CITY OF ALBUQUERQUE

Hydrology Section of the Planning Department

November 29, 2017

**Re: Picasso RV - 7800 Jacs Ln. NE
Grading & Drainage Plan Engineer's Stamp Dated 11/21/2017
(D16D002A6)**

SECTION C-C
NTS

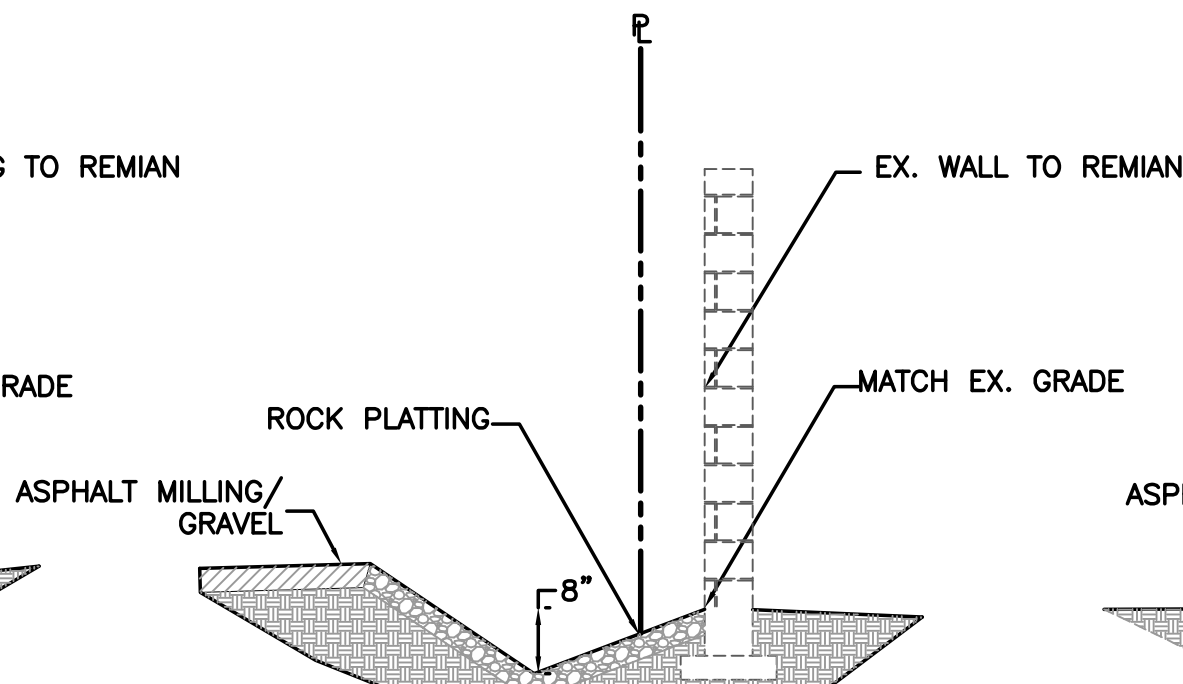
3. Similarly the hydraulic capacity calculations of the swale in section C-C should either be revised in the report to match the geometry of the section on the G&D Plan or the revised calculations can be shown on the G&D Plan next to the section. The detail and the calculations should agree.

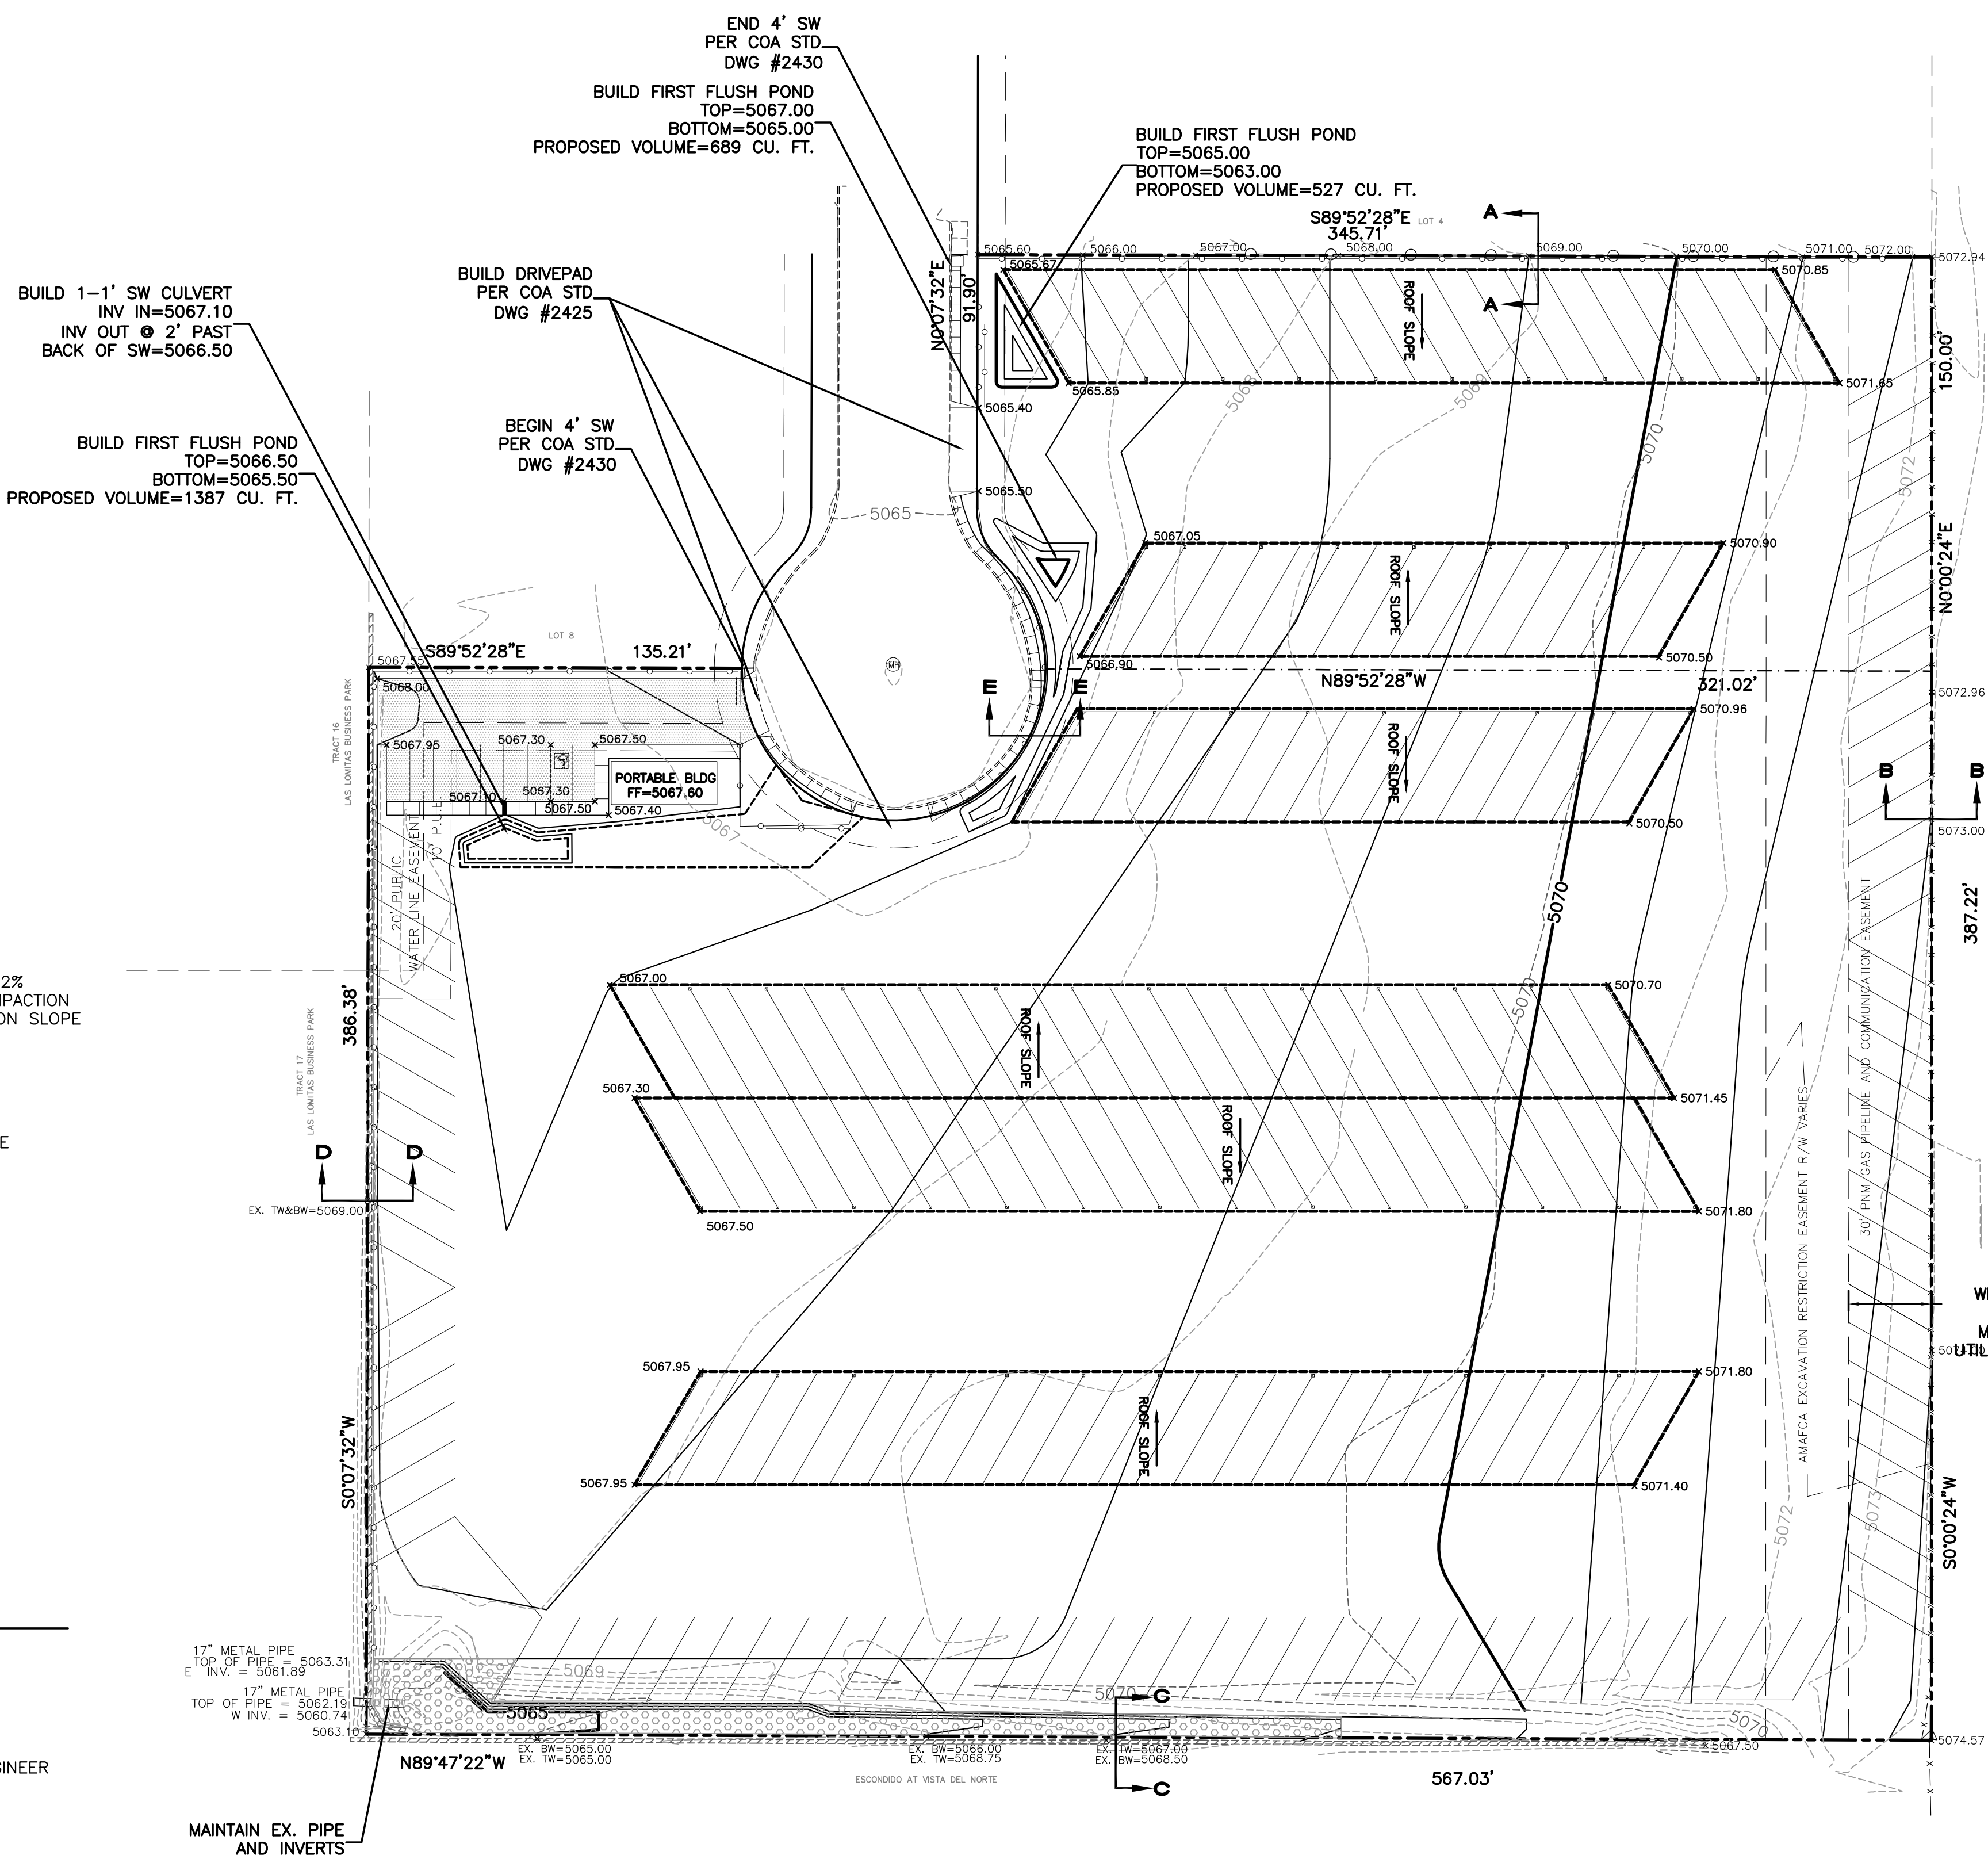
1. Flow arrows and spot elevations should be added showing the onsite swale next to Jacs Ln. that will divert onsite drainage into the ponds before it enters the public right of way.

2. A typical section showing the horizontal and vertical dimensions from the right of way line of Jacs Ln. to the curb and gutter, sidewalk, and onsite drainage swale should be shown on the G&D Plan. Hydraulic capacity calculations should be shown next to the section of the onsite swale.

4. Please add a big caution note in the vicinity of the existing 30' PNM Gas Pipeline and Communication easement on the east side of this property.
5. Written approval of this plan is required from PNM.
